From: Amanda Scholes on behalf of Planning.Responses
Sent: 10 April 2018 09:08
To: Planning Scanning
Subject: FW: AW/45/18/HH 19 Kingsway Alnwick

From: Andrew Wood
Sent: 09 April 2018 13:48
To: [REDACTED]
Cc: 'bryan.butcher@btopenworld.com'
Subject: RE: AW/45/18/HH 19 Kingsway Alnwick

sheet 3 of 5

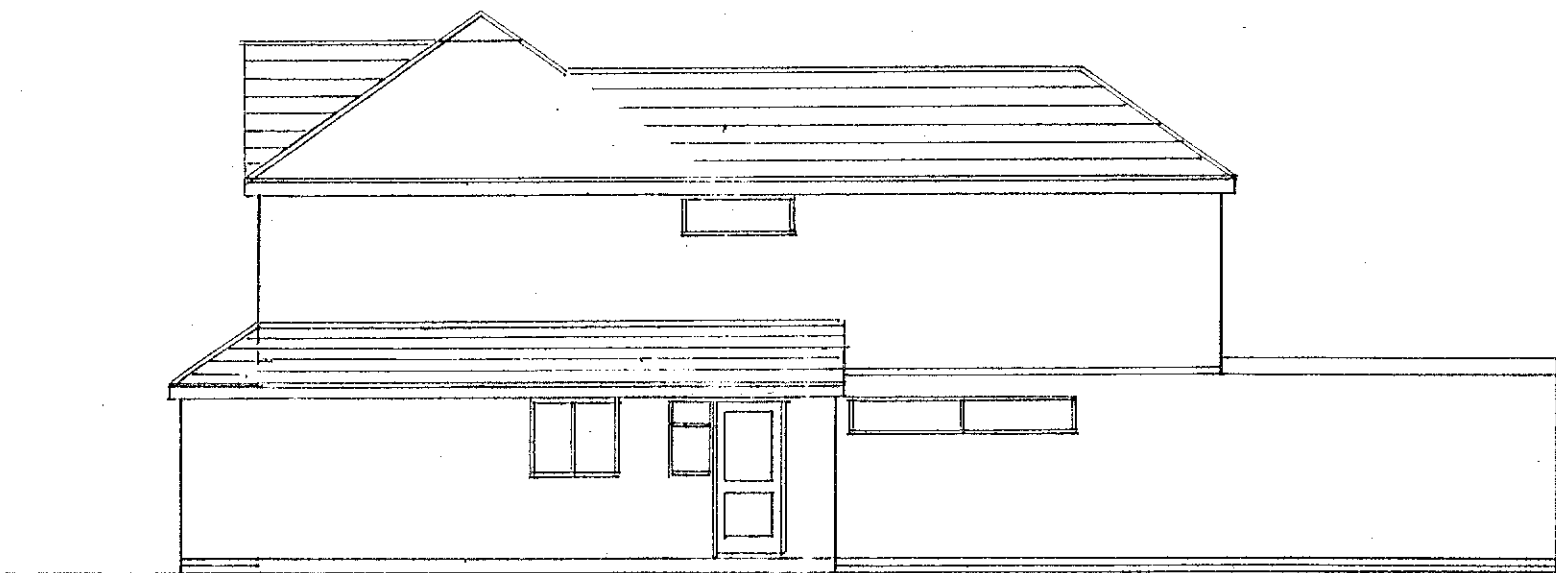
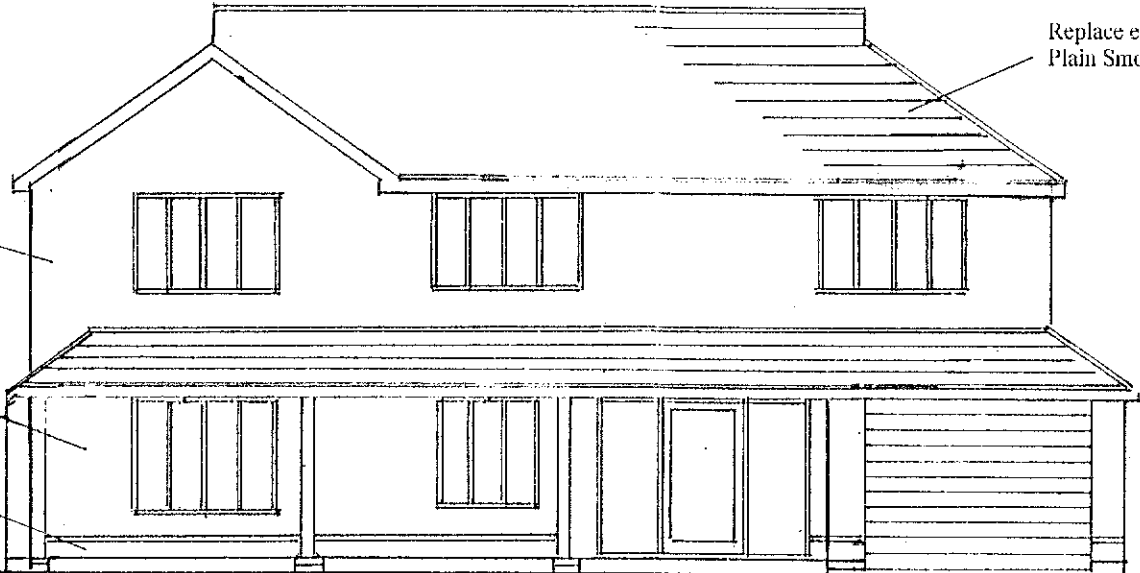
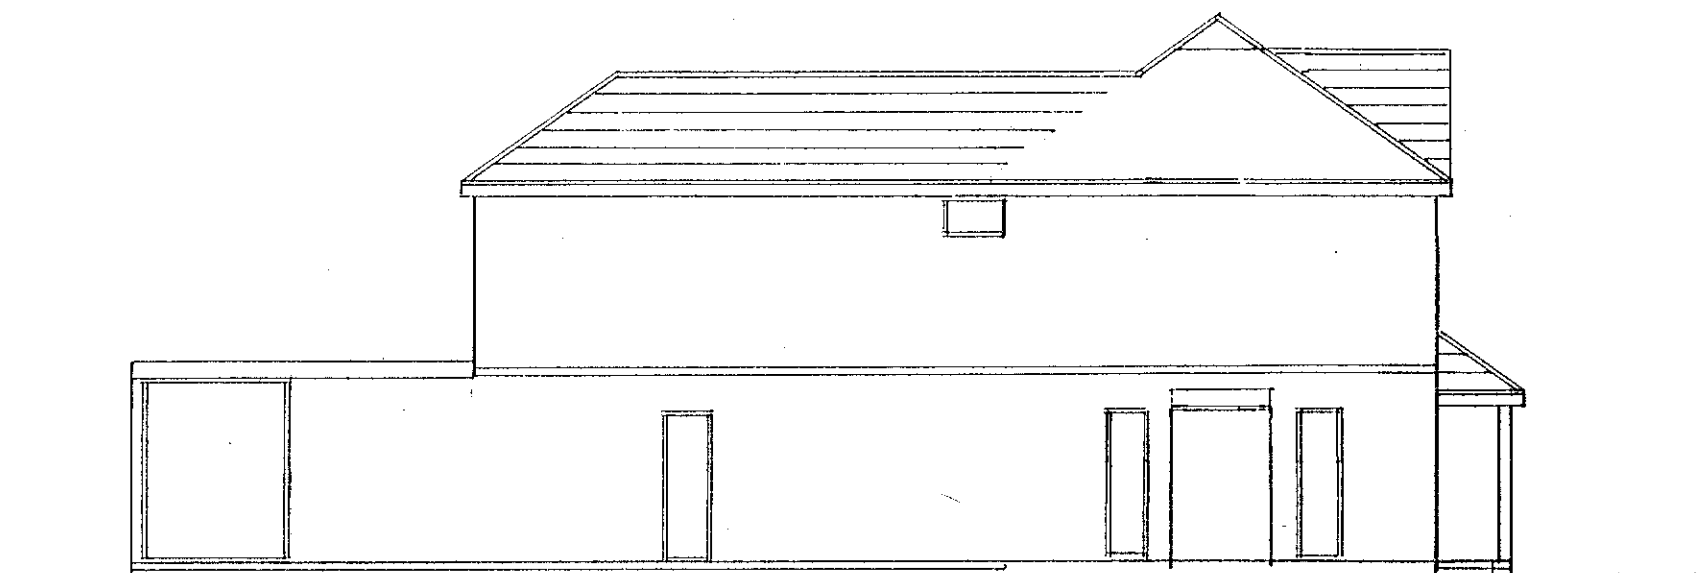
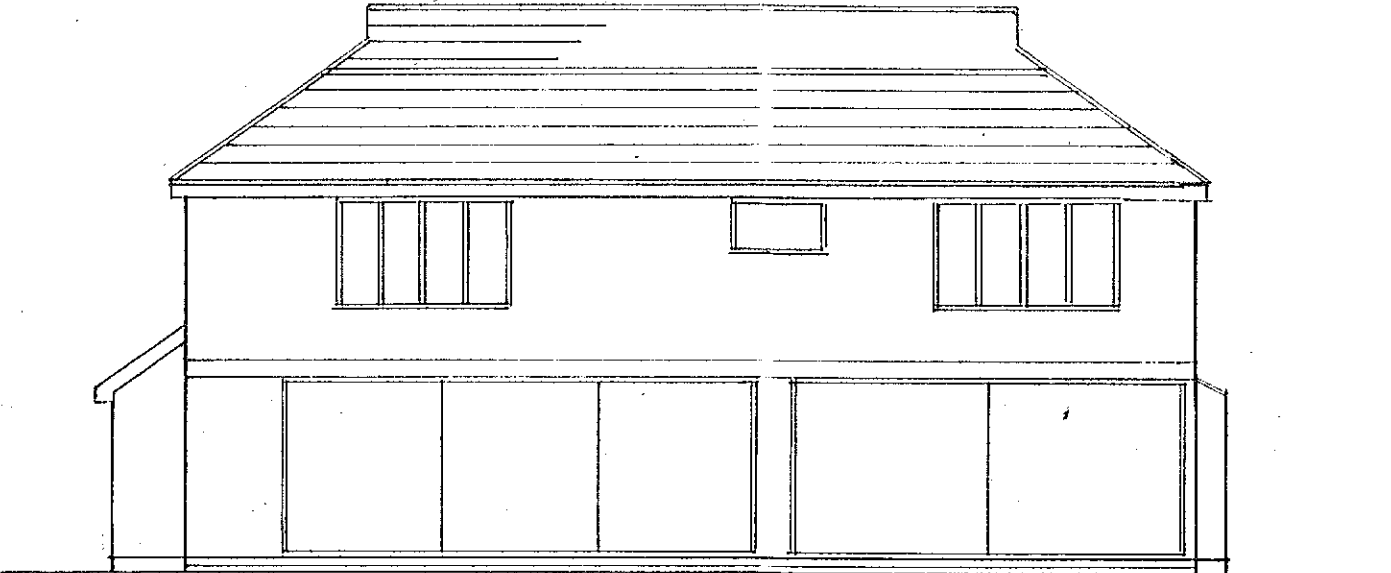
Further to our conversation last Friday regarding our planning application. The colour of the roof tile is noted as grey but as you mentioned you thought it might be more in keeping to stay with the original colour red/brown of roof tile. We are happy for this so if all else is agreeable can we do approval subject to confirmation of materials for roof to your agreement.

You also mentioned and questioned the gable end. This we discussed with Richard at pre meeting and on his suggestion we put it in as it is more in keeping with the other properties on the estate.
